PROPOSED SOUTH EAST ANGLIA LINK (SEA LINK) DEVELOPMENT CONSENT ORDER

PINS REFERENCE: EN020026

LONDON GATEWAY PORT LIMITED (LGPL) ()

DEADLINE 2: LGPL’S COMMENTS ON DOCUMENTS SUBMITTED BY THE APPLICANT AT DEADLINE 1 AND DEADLINE 1A

Plate 2.1 Stakeholder areas of interest with regard to under-keel clearance

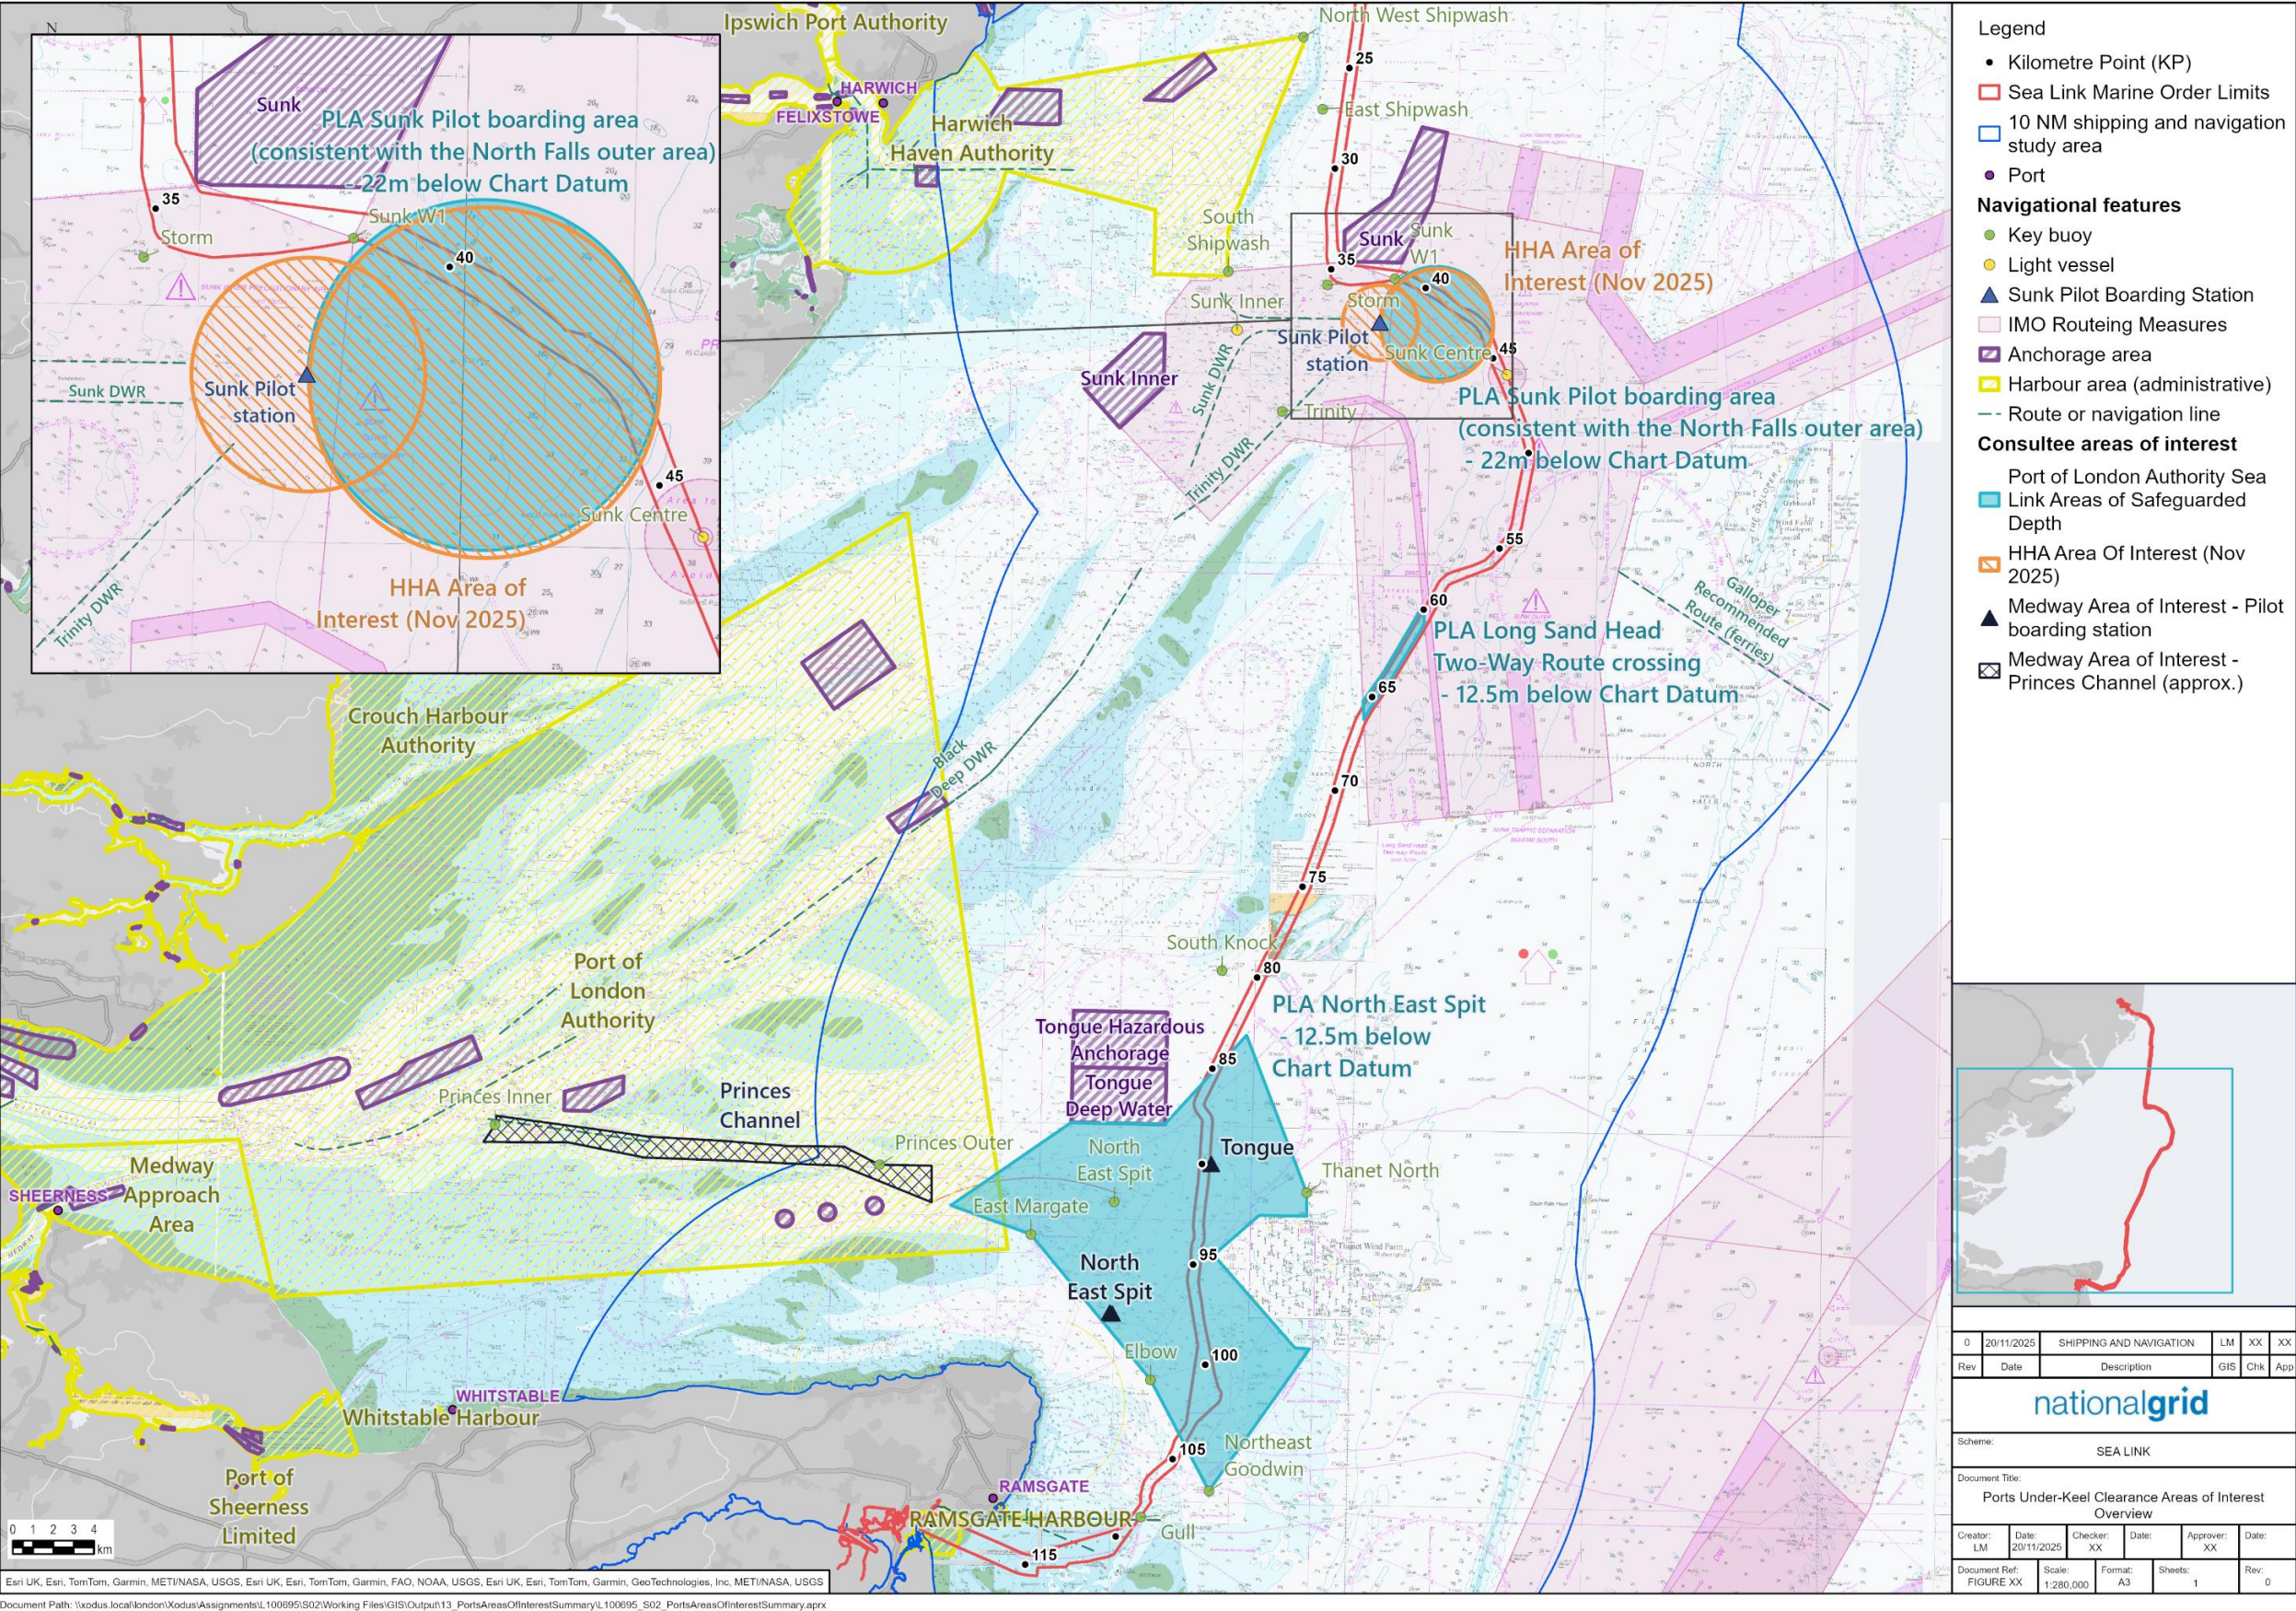
Technical Note Paragraph Number	Applicant's Analysis	LGPL Comment / Response
2.1.4 (Introduction)	<p><i>The following summarises the ongoing engagement with stakeholders on the matter of under-keel clearance:</i></p> <ul style="list-style-type: none"> <i>The Port of London Authority (PLA) has provided GIS data for three Areas of Safeguarded Depth (the Areas of Interest): — 1) "Sunk Pilot Boarding area" where PLA have requested 22 m below Chart Datum (CD) minimum water depth; — 2) "Long Sand Head Two-Way Route crossing area" where PLA request 12.5 m below CD to be preserved; and — 3) "North East (NE) Spit area" where 12.5 m below CD is to be preserved.</i> <i>The PLA also require in all areas of interest (1) to (3) to makes allowance for an 'over-dredge' tolerance of 0.5 m in addition to the stated depths attributable to standard dredging methodology.</i> <i>Harwich Haven Authority (HHA) has also requested that 22 m below CD is safeguarded within "the Sunk area". Further detail on precise geographical extent of this area was provided on 7 November 2025. Further communication has established that the area of interest for the HHA consists of two circles centred at the Sunk Pilot Boarding Station charted and actual boarding locations.</i> <i>London Gateway Port has expressed that they support the PLA in seeking safeguarding of 22 m in the PLA's "Sunk Pilot Boarding Area", and 12.5 m below CD within the "Long Sand Head Two-Way Route crossing area" and "NE Spit area". They also have interest in regards powers of dredging rights adjacent to the Sunk which need to be considered.</i> <p>[...]</p>	<p>LGPL are of the view a Requirement must be added to the draft DCO [REP1-036] to ensure a dredge depth of 22 metres below CD is not precluded in the Sunk Pilot Boarding Area. LGPL also endorses the proposed over-dredge tolerance 0.5 metres in addition to the stated depth proposed by the PLA and this must also be secured as part of the Requirement. These are allowances are required to ensure larger vessels in the future can use the Sunk route into the Thames Estuary.</p> <p>For the avoidance of doubt, LGPL maintains the view expressed in its Written Representations [REP1-142] that 12.5 metres below CD should also be maintained at Long Sand Head Two-Way Route crossing area and the North East Spit area. An allowance of 0.5 metres for over-dredging should also be secured in addition to the stated depths. Again, this safeguarding must be secured by way of a Requirement in the draft DCO.</p>

**Plate 4.1 Overview of the water depths within the Area of Interest and the Sunk wider area. Extract of Figure 10:31 from the Integrated Geophysical and Geotechnical Survey Report (NEXT GEO 2025)**

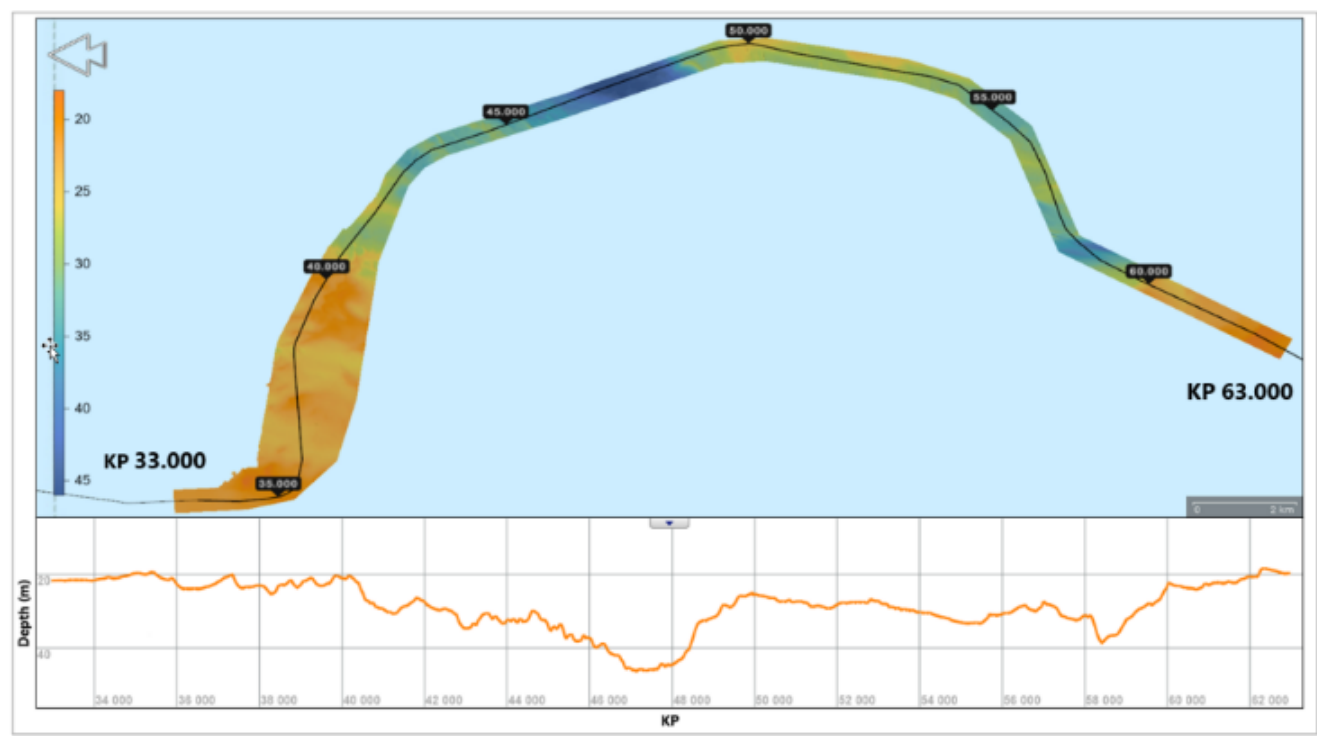
Technical Note Paragraph Number	Applicant's Analysis	LGPL Comment / Response
	<p><i>which the Applicant could incorporate into detailed cable design plans, other than the intention to require 22 m in the future throughout the PLA's "Sunk Pilot Boarding area".</i></p> <p><i>There are no known cable crossings planned within the PLA's "Sunk Pilot Boarding area."</i></p>

**Plate 4.4 Overview of the water depths within the “NE Spit area” and the wider area. Extract of Figure 10.45 from the Integrated Geophysical and Geotechnical Survey Report (NEXT GEO 2025)**

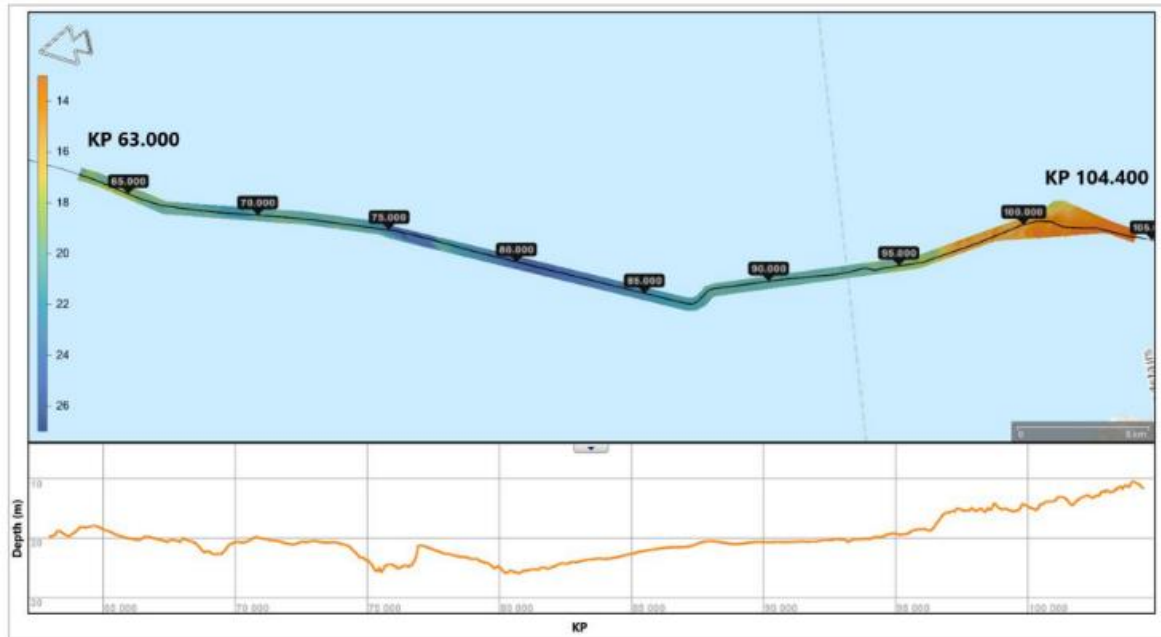
2.3.14 – 2.3.16 (PLA's NE Spit Area)	<p><i>The Applicant has been engaging with the Port of London Authority in respect of under-keel clearance within the PLA's "NE Spit area". Of particular consideration is the GridLink planned cable crossing, which is expected to be located within this area at approximately KP 101.</i></p> <p><i>The Applicant has engaged with GridLink to understand the development's plans for installation in this area, and with the goal of co-engineering and collaborating as required in order to ensure that the PLA's requirement for 12.5 m depth below CD can be met within the "NE Spit area", which is an area with shallow sections.</i></p> <p><i>The Applicant is satisfied that it has a solution to ensure that the 12.5 m depth is preserved even at the GridLink crossing location, by moving the planned Sea Link cable route at this point into deeper waters to the east (while still within the Order Limits) ensuring sufficient water depth above the expected crossing location. The Applicant had kept the Order Limits wide here to enable such solutions to be possible.</i></p> <p><i>The Applicant is undertaking the necessary technical assessments in order to reach agreement on wording of Protective Provisions on this matter.</i></p>	<p>LGPL are content for the GridLink crossing at NE Spit to be located in deeper waters so as to ensure sufficient water depth in the area of concern. We assume therefore that there would be no difficulty in entering into the Requirement sought in the DCO. LGPL's rights to approve the cable specification and installation plan (CSIP) must be secured by way of protective provisions or pursuant to the deemed marine licence.</p> <p>LGPL provided the Applicant with example wording for the relevant protective provision on 21 November 2025.</p>
